Your ref:
Our ref: 23/01700/F
Please ask for: Lynn-Marie Elliott
Direct dial:
E-mail: borough.planning@west-norfolk.gov.uk

Details: **"Retrospective" Extension to rear of the property at 65 Recreation Drive
Southery Downham Market Norfolk PE38 0NB**

I have received a planning application as detailed above but cannot process it until I receive some more information:

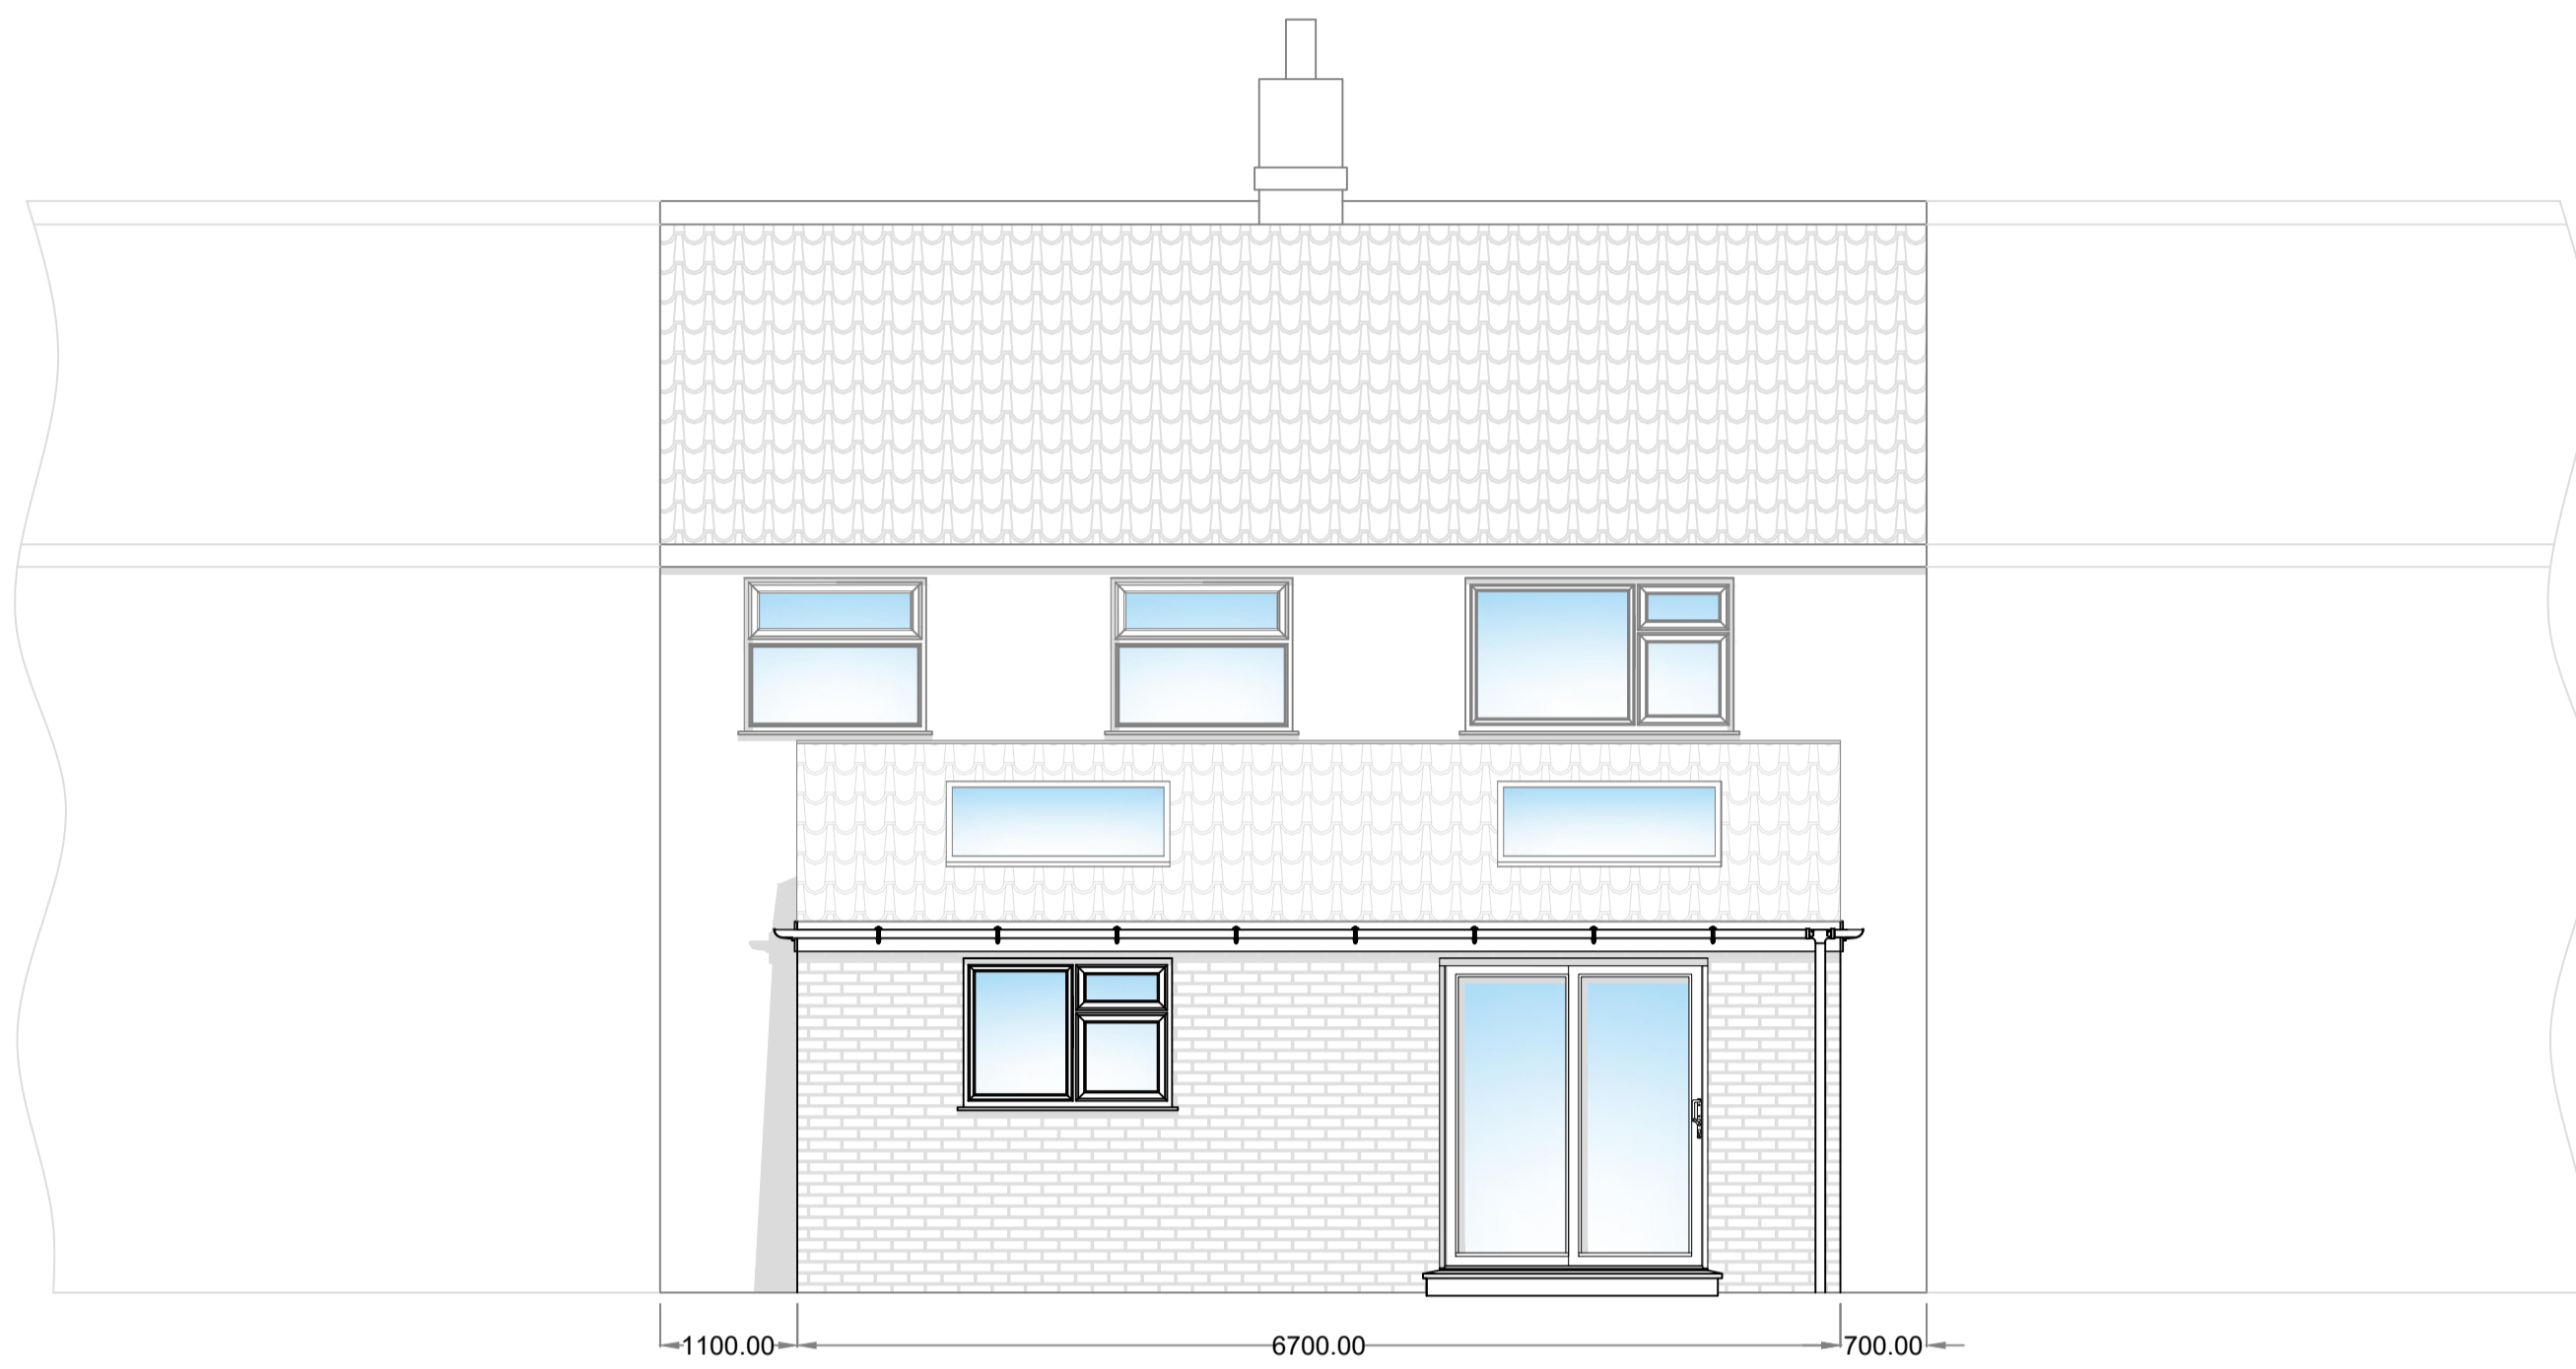
1. As the property lies within an area at risk to flooding, please complete the simplified Matrix and return it. The Matrix can be found at https://www.west-norfolk.gov.uk/info/20173/information_for_planning_agents/231/flood_risk_information
2. The annotation on the drawing(s) submitted with your application refers to the drawing being not to scale. Please remove any such reference for the purposes of the planning application.
3. Please mark on floor plan to specify that they are proposed plans.
4. Please confirm if site levels are to remain as existing.
